Our ref: LS/23716SPAB/13
Application ref: 3/2013/0012

29th January 2013

BARN ADJACENT TO ROCK HOUSE, TOWN END, SLAIDBURN

Drawing Title
BUILDING REGULATIONS:
Proposed plans and elevations.

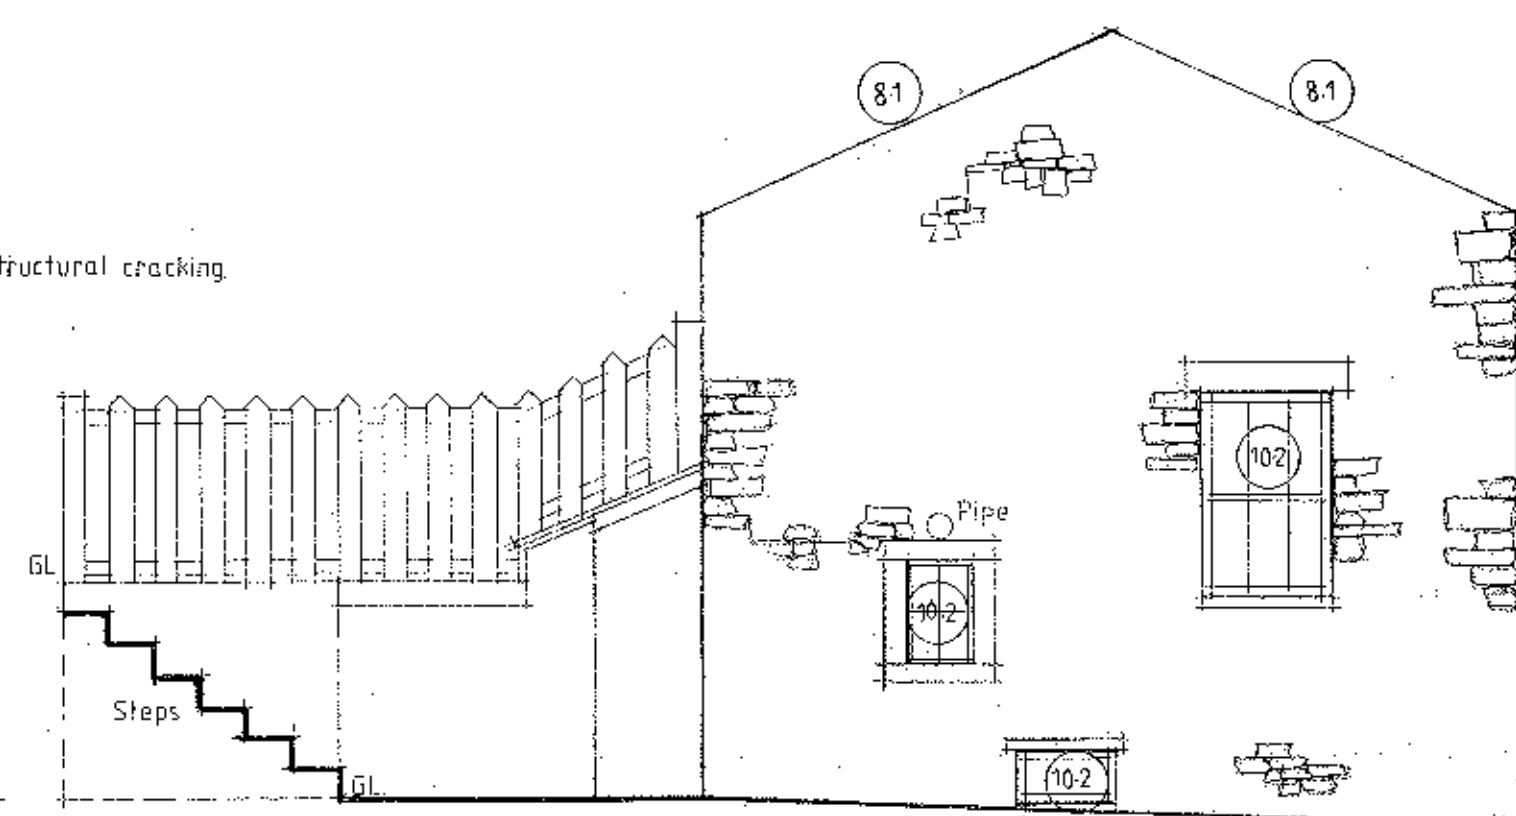
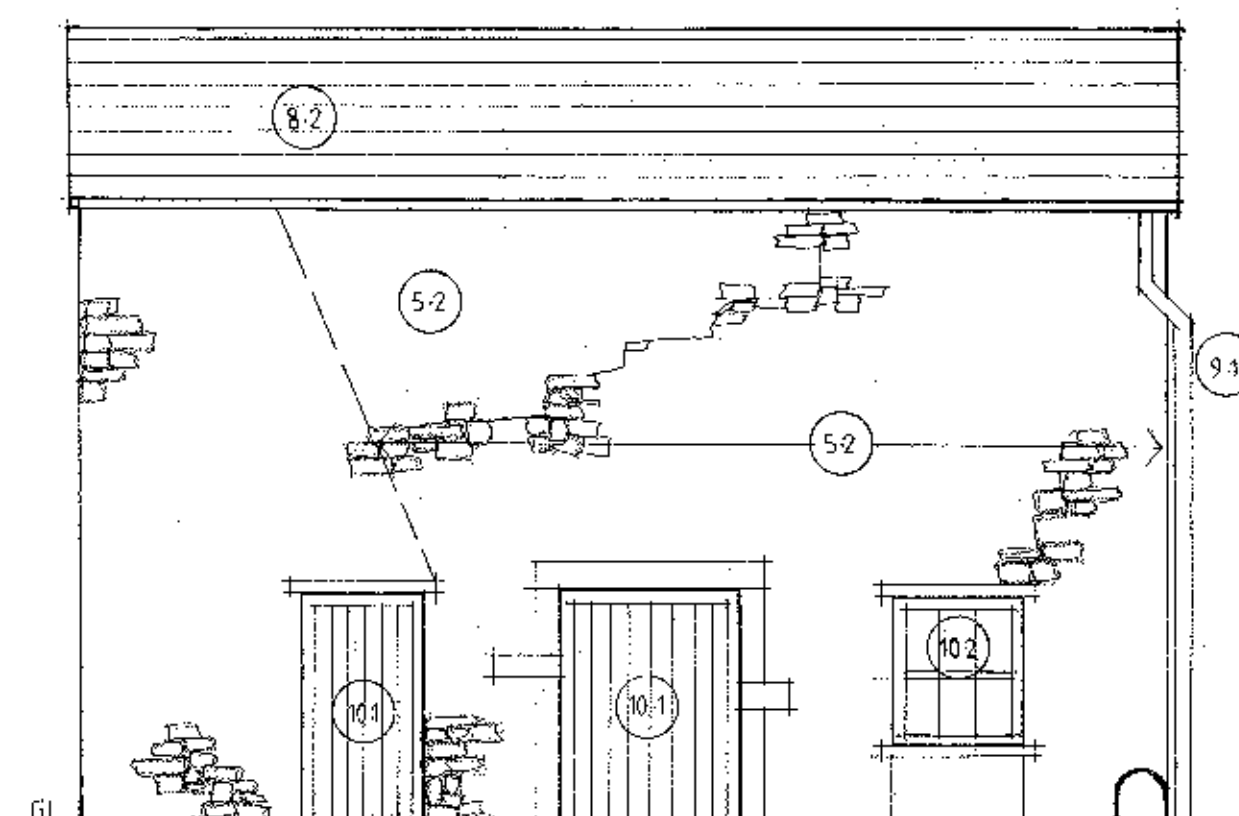
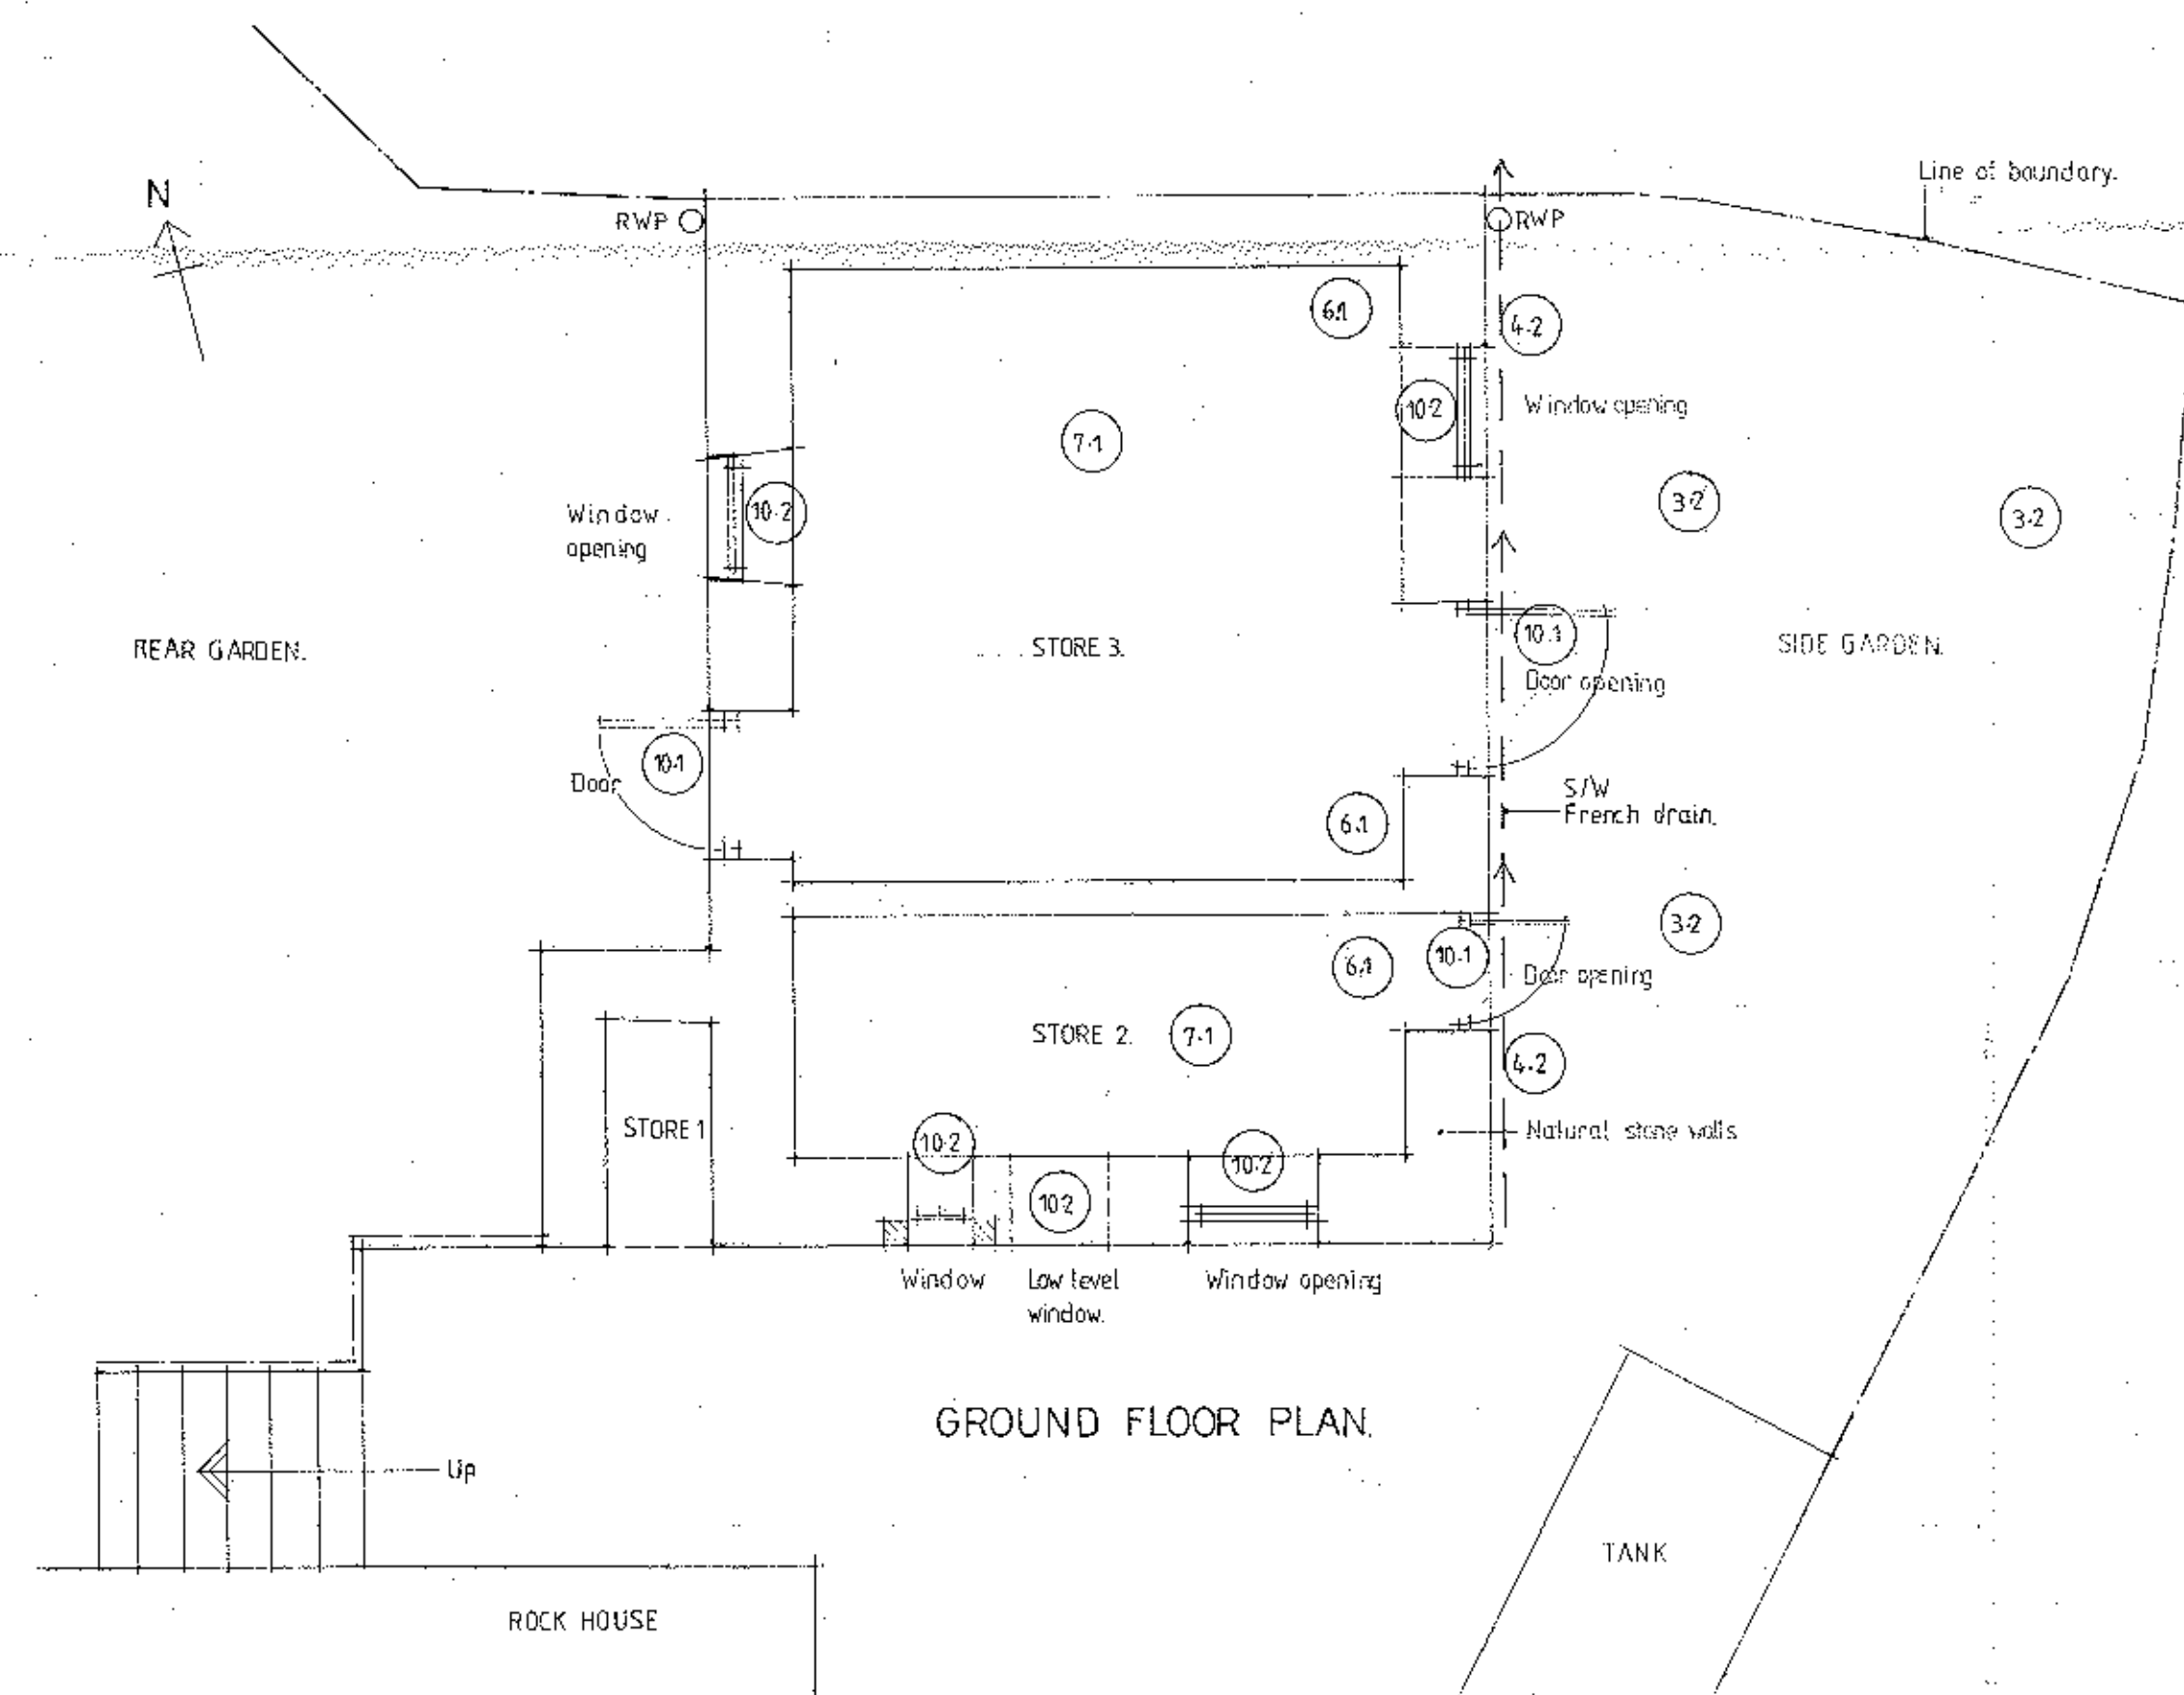
Downpipes: For ease of cleaning and to avoid blockages, we would suggest that straight pipes are specified and that the swan neck detail omitted.

Timber finishes: Oak weathers naturally to a subtle grey finish, and does not necessarily require 'Dulux Naked Wood' which is likely to peel over time. A painted finish would be more traditional and in keeping with the style of building.
